City of Portland, Maine - Building or Use Permit Application
 389 Congress Street, 04101 Tel: (207) 874-8703, Fax: (207) 874-8716

Permit No: 06-0913	Issue Date:	CBL: 082 D012001
------------------------------	--------------------	----------------------------

Location of Construction: 19 ST GEORGE ST	Owner Name: FREEMAN ANNA J	Owner Address: 19 ST GEORGE ST	Phone:
Business Name:	Contractor Name: MWS, Inc.	Contractor Address: 71 Portland Rd. Kennebunk	Phone 2079852300
Lessee/Buyer's Name	Phone:	Permit Type: Additions - Dwellings	Zone:

Past Use: Single Family	Proposed Use: Single Family Prefab Patio room and new deck	Permit Fee: \$237.00	Cost of Work: \$24,000.00	CEO District: 3
Proposed Project Description: Prefab Patio room and new deck		FIRE DEPT: <input type="checkbox"/> Approved <input type="checkbox"/> Denied	INSPECTION: Use Group: Type	
		Signature:	Signature:	
PEDESTRIAN ACTIVITIES DISTRICT (P.A.D.)				
Action: <input type="checkbox"/> Approved <input type="checkbox"/> Approved w/Condition <input type="checkbox"/> Denied				
Signature:		Date:

STAIR
Detail

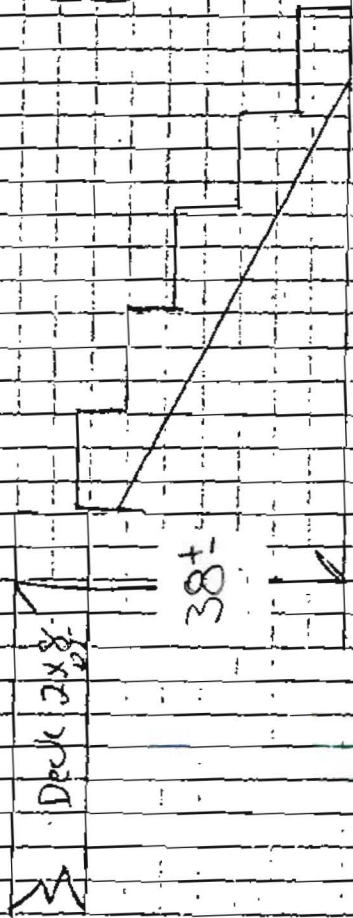
8/7/06-tmm: need detail on side landing and stairs, is the existing deck structurally adequate?, need copy of product info for which room is going in. left message w/MWS.

8/11/06-tmm: ok to issue - rec'd info
